# OBSERVATION/SUBMISSION TO PLANNING APPLICATION

Case Reference: 324113

**Re: Observation to the proposed development of open-cycle gas turbine (OCGT) and generator with ancillary equipment.**

Location: Pollnagroagh and Rathmorrissy (Townlands), Athenry, Co. Galway

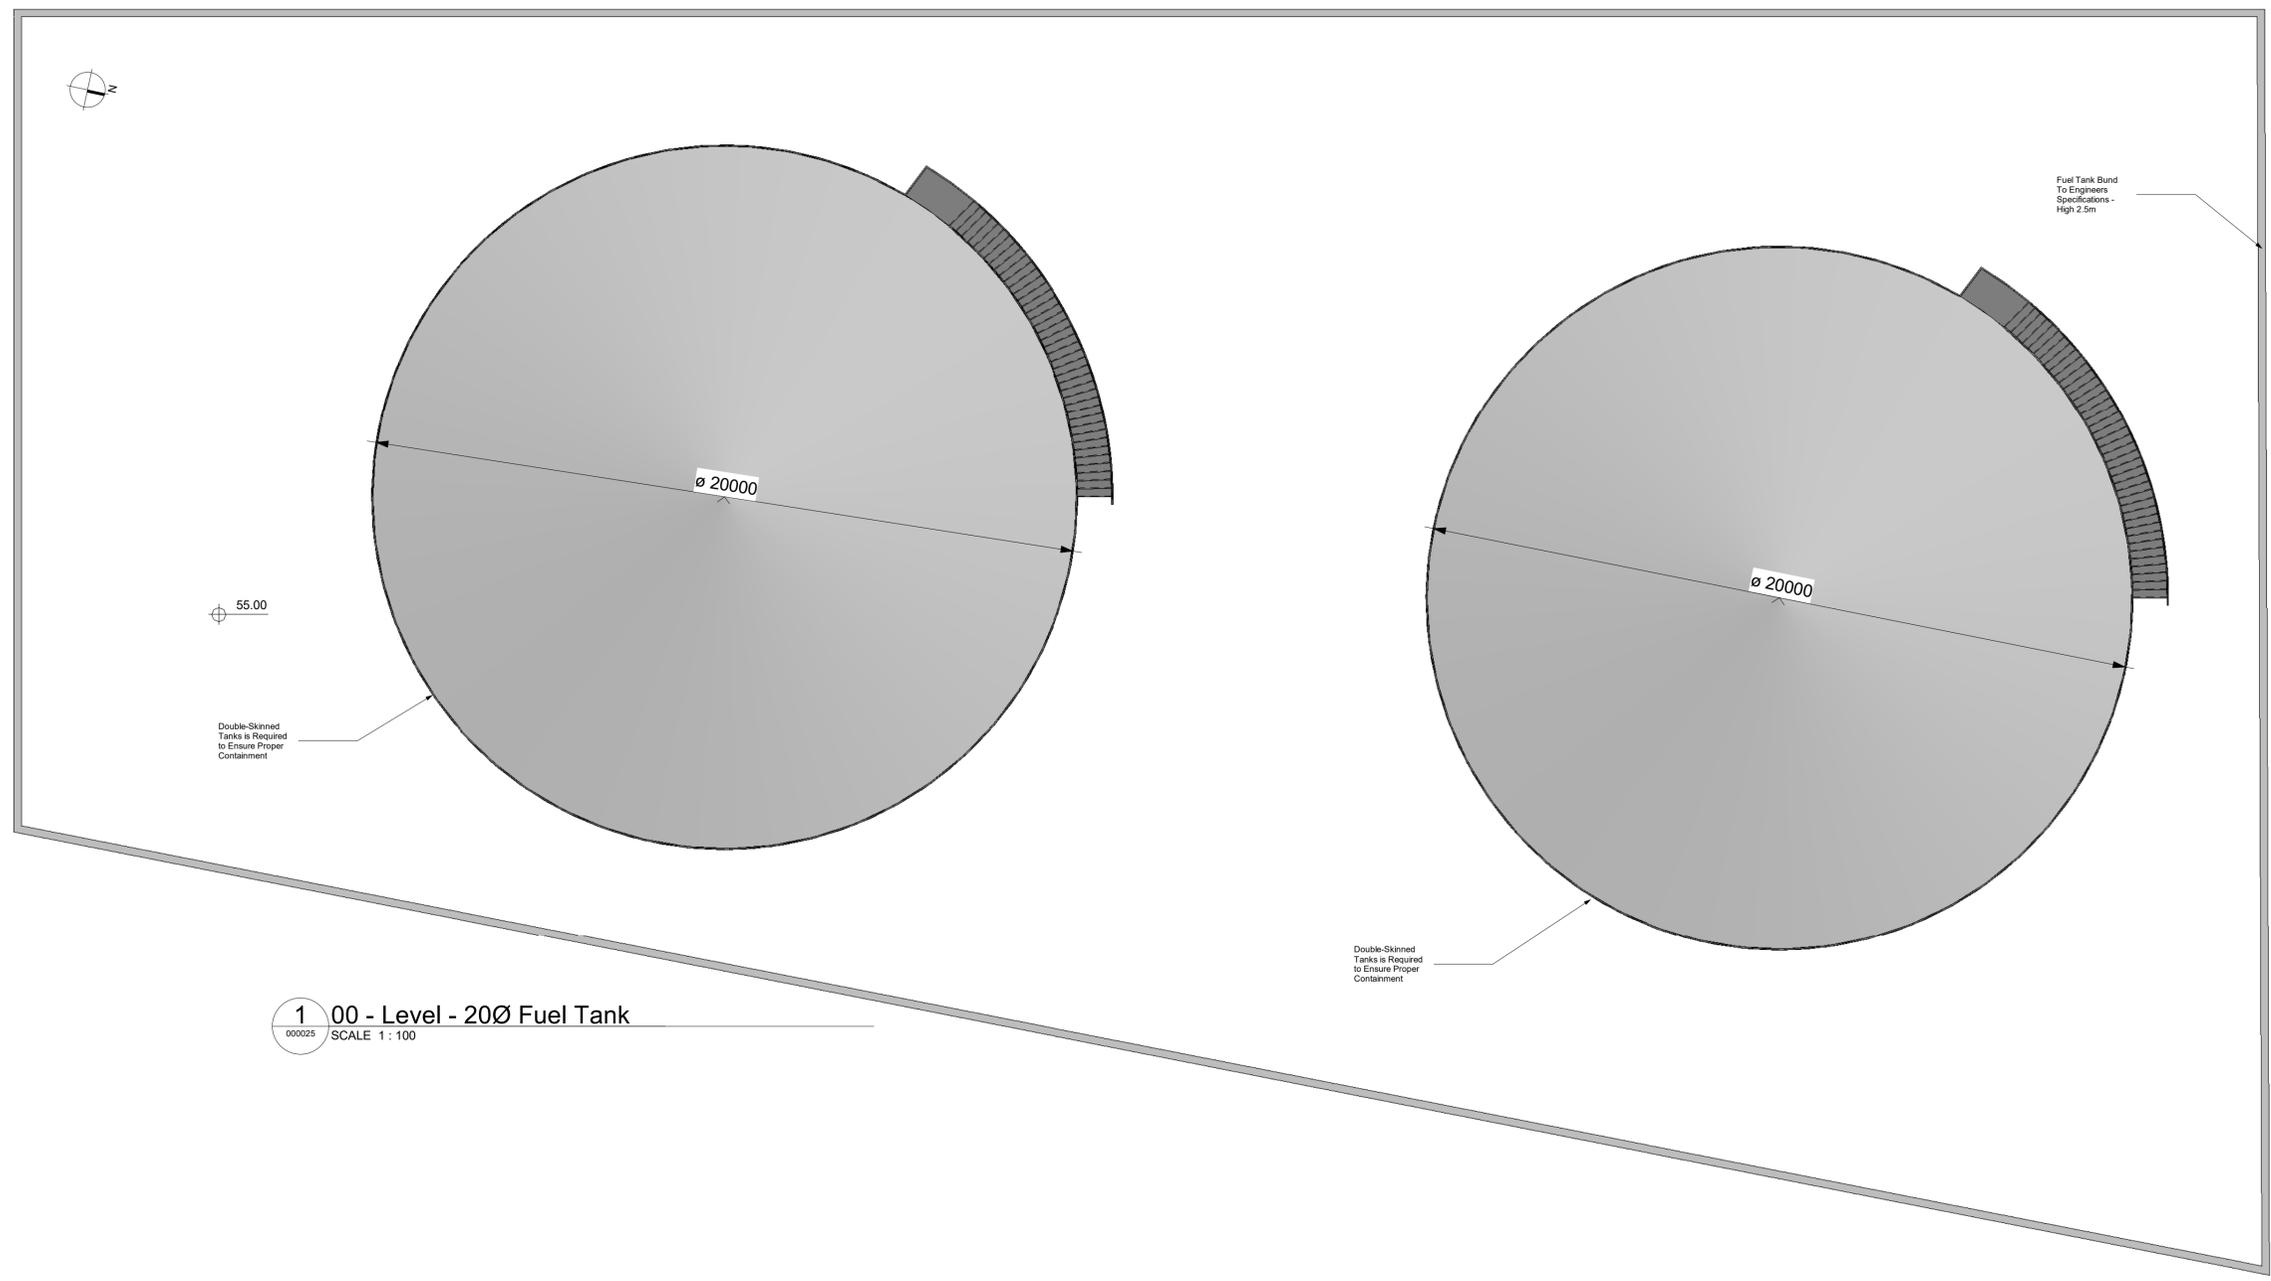
I am concerned about the risks of soil and groundwater contamination from this proposed peaker plant. The development would involve the storage and handling of fuels such as diesel, along with lubricating oils and other chemicals, all of which could pose a risk to the surrounding environment. There is a real possibility that these substances could leak, spill, or enter the ground through surface runoff over the long lifetime of the facility, potentially up to 2050, and even small but repeated incidents could lead to a gradual build-up of pollution in soil and groundwater.

This is particularly worrying because once groundwater becomes contaminated, it is extremely difficult and costly to remediate, and the impacts can persist for decades. This raises serious concerns about the long-term protection of local water resources and the surrounding environment. There remains uncertainty about whether these risks have been adequately managed, raising substantial worries that the project might cause permanent damage to water quality. This would violate the obligations under EU Directive 2000/60/EC, which mandates the protection of water bodies and prohibits their deterioration.

Purpose		PLANNING			
Title		SITE ACCESS SIGHTLINES			
Original Scale	Design/Drawn	Checked	Authorised		
SHOWN at A1	PS	ND	AJB		
Date	Date	Date	Date		
01.12.25	01.12.25	01.12.25	01.12.25		
Status	Drawing Number	Rev			
A2	PEK3-ATK-ZZ-01-DR-CE-901200	0

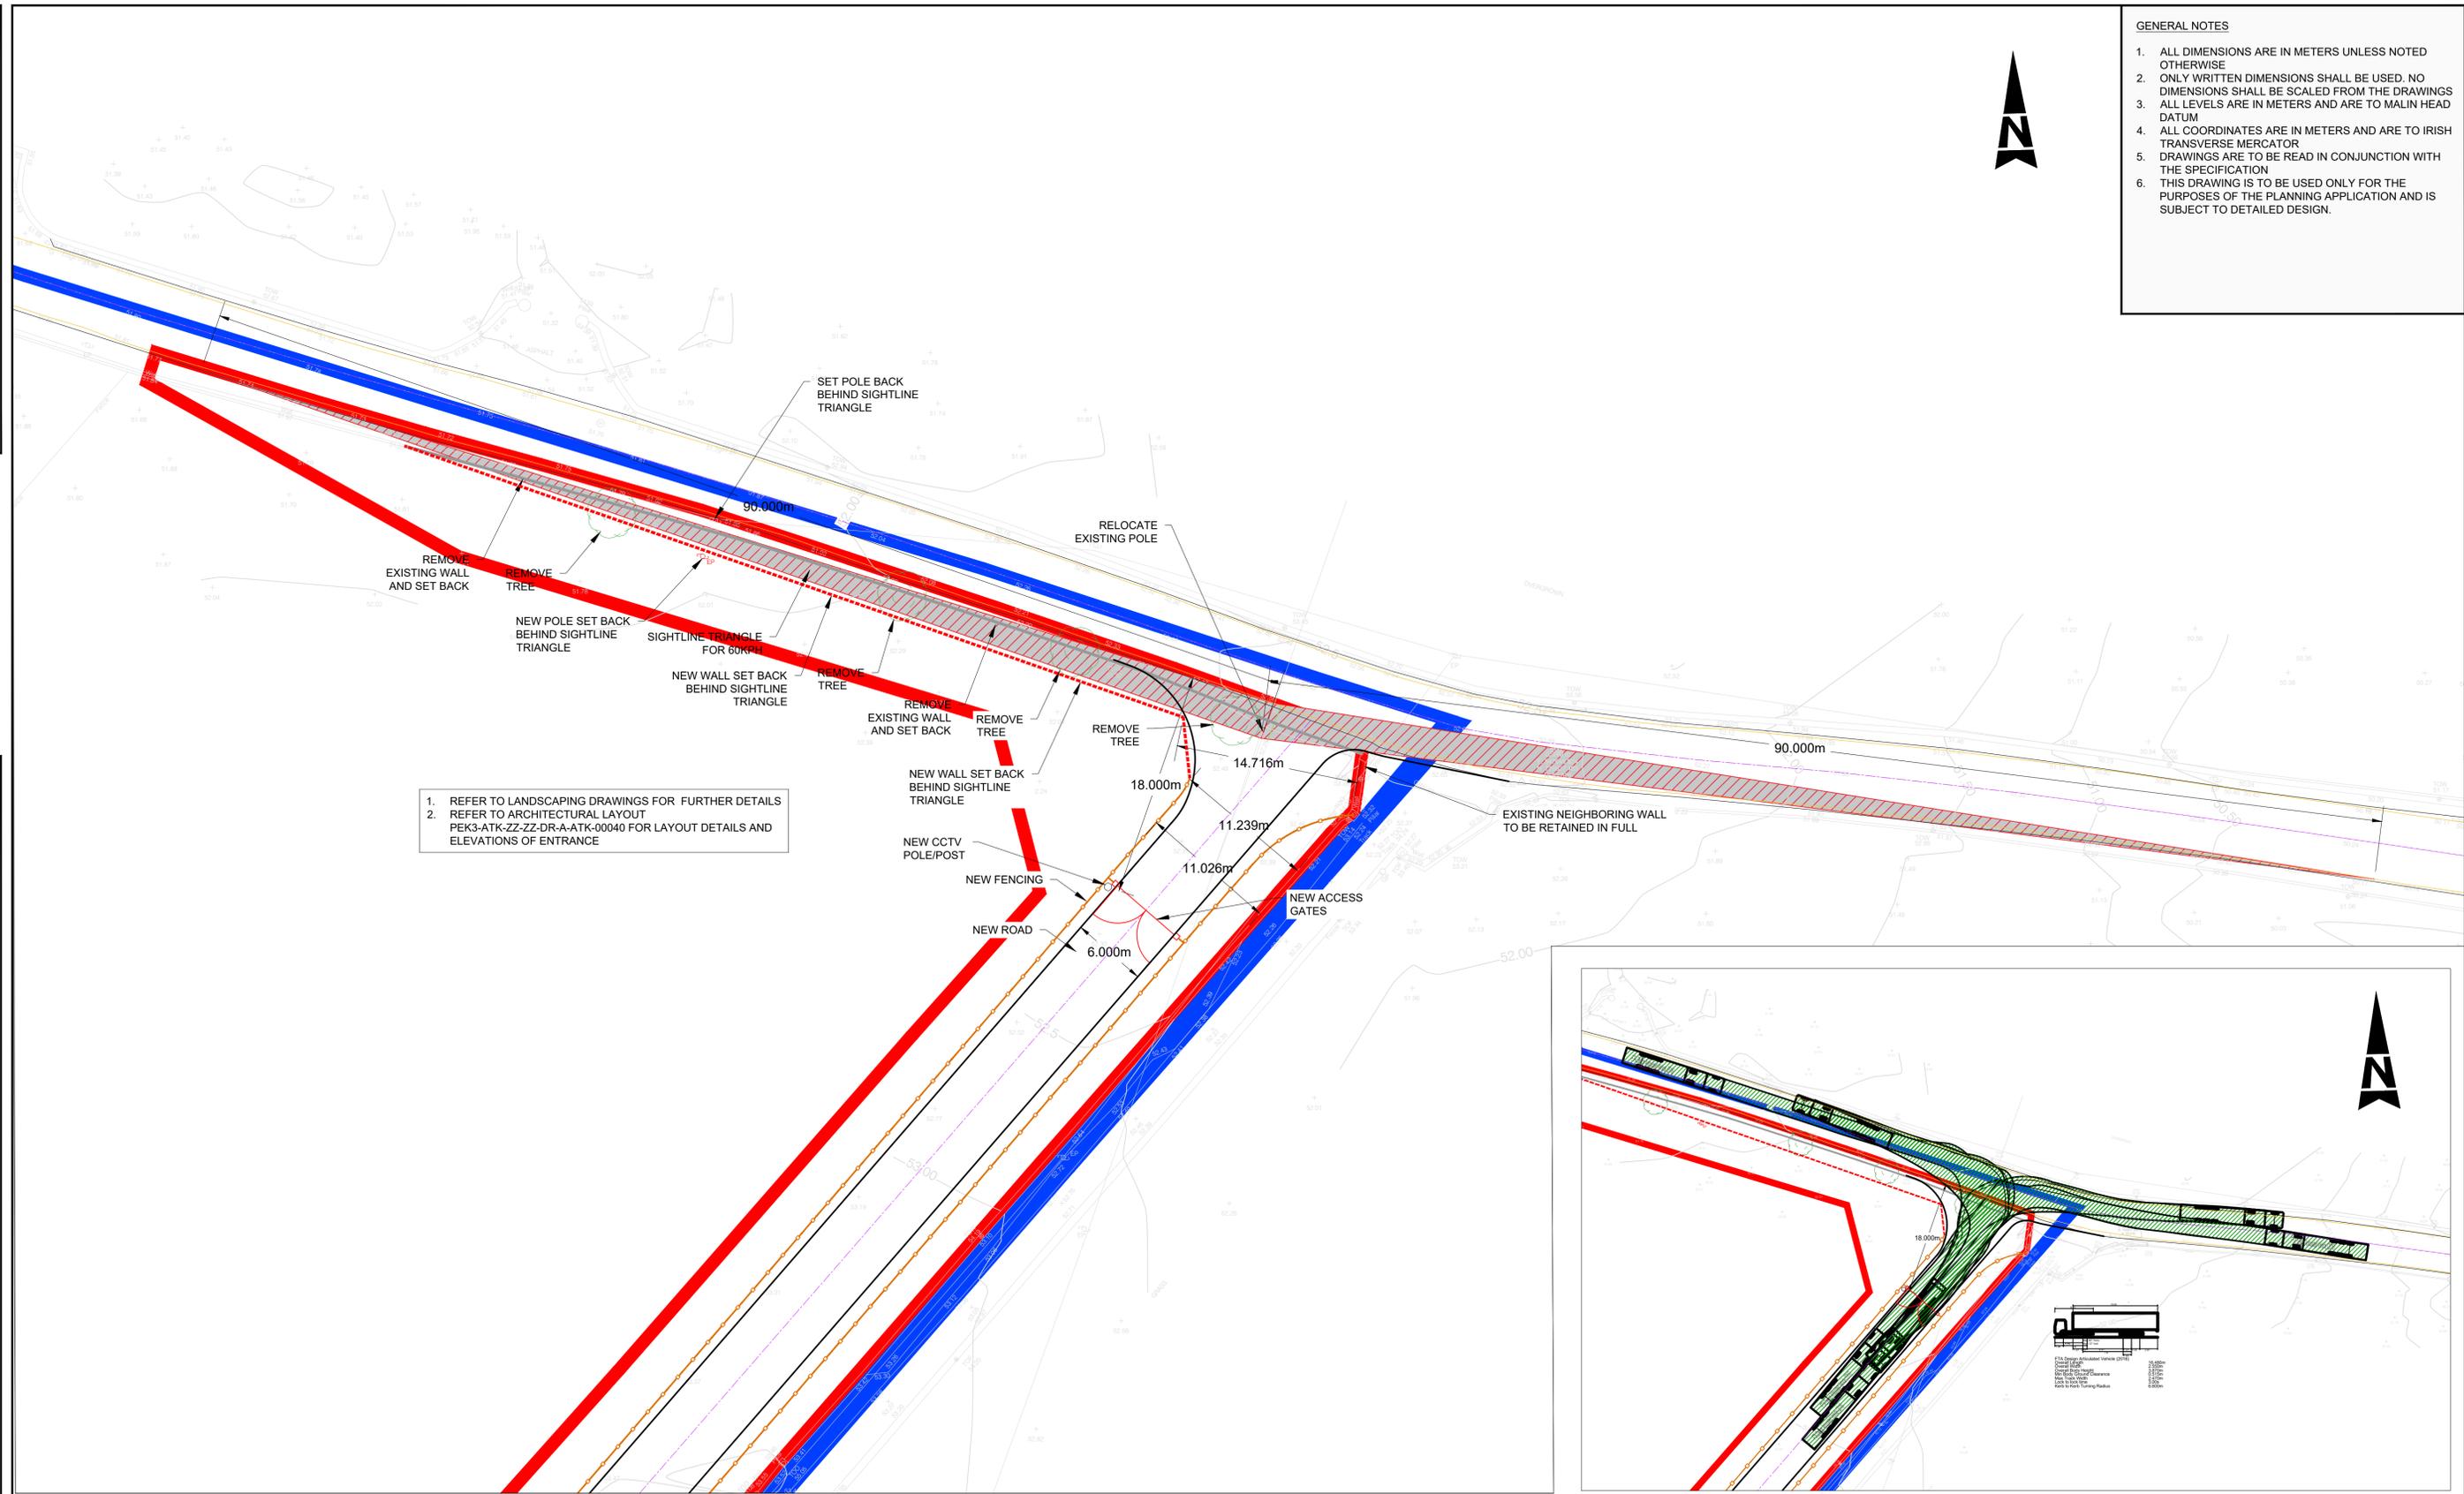
The placement of a site entrance at this hazardous location on the L3103 raises serious safety concerns. The road is already constrained by its narrow width, the absence of a hard shoulder, and extremely poor visibility due to blind dips and sharp corners, yet the Environmental Impact Assessment does not appear to fully address the safety implications of introducing an access point at this location. There are also concerns that the cumulative impact of additional traffic has not been properly assessed, including construction traffic, ongoing operational traffic, and fuel deliveries, and the interaction between heavy goods vehicles and existing road users—such as local traffic, school-related movements, and agricultural machinery—has not been examined in sufficient detail. Overall, the lack of a thorough and robust traffic safety assessment creates significant uncertainty as to whether the local road network can safely accommodate this development.
